from
**Southern
Water**

Your ref
BN/151/20/PL

Proposal: Erection of 1 No. 4 bedroom detached dwelling with detached carport (resubmission following BN/46/20/PL). This site is in CIL Zone 3 & is CIL Liable as new dwelling & is a Departure from the Development Plan.

Site: BN/151/20/PL: - Land Rear of Poachers, Eastergate Lane, Eastergate, PO20 3SJ.

PROPOSED SITE PLAN

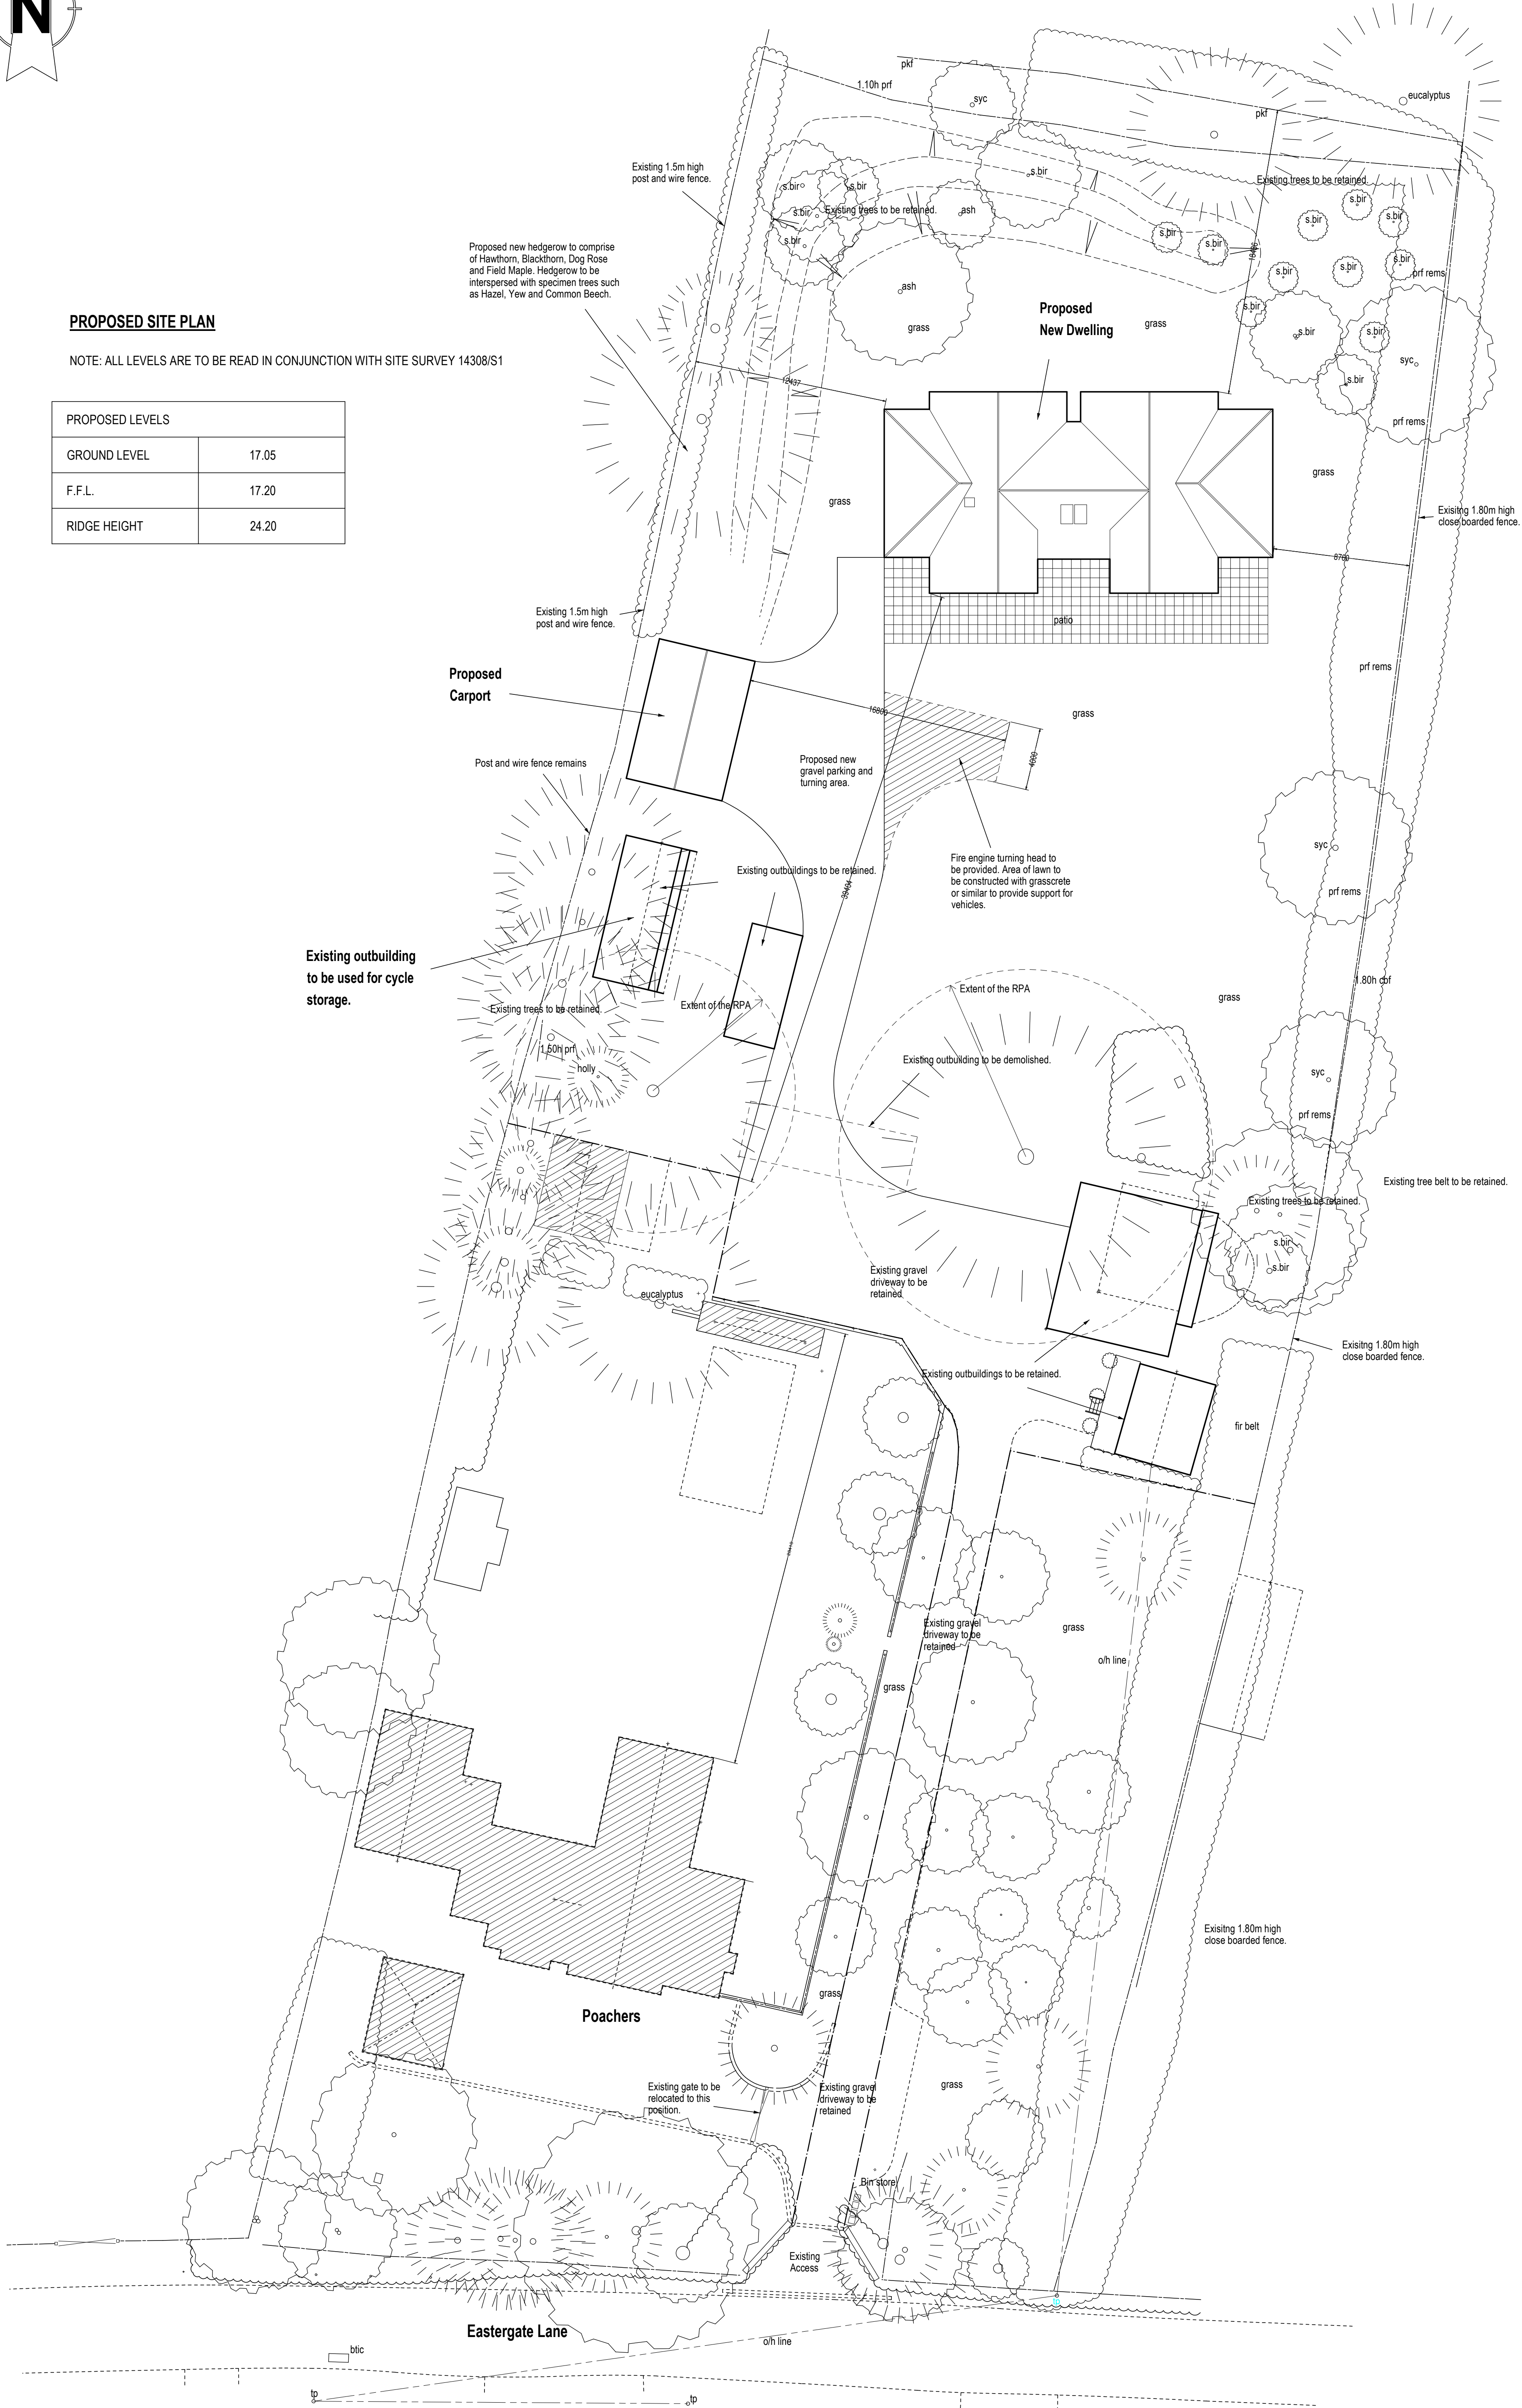
Southern Water would not support the proposals for a private treatment plant in the presence of public foul sewerage network in the close vicinity of the development site. The foul sewerage shall be disposed in accordance with Part H1 of Building Regulations hierarchy.

It may be possible for the foul flows from the proposed development to be connected to a nearby public sewer, and the applicant shall investigate this option.

The Environment Agency should be consulted directly by the applicant regarding the use of a private wastewater treatment works which disposes of effluent to sub-soil irrigation.

The Council's Building Control officers or technical staff should be asked to comment on the adequacy of soakaways to dispose of surface water from the proposed development.
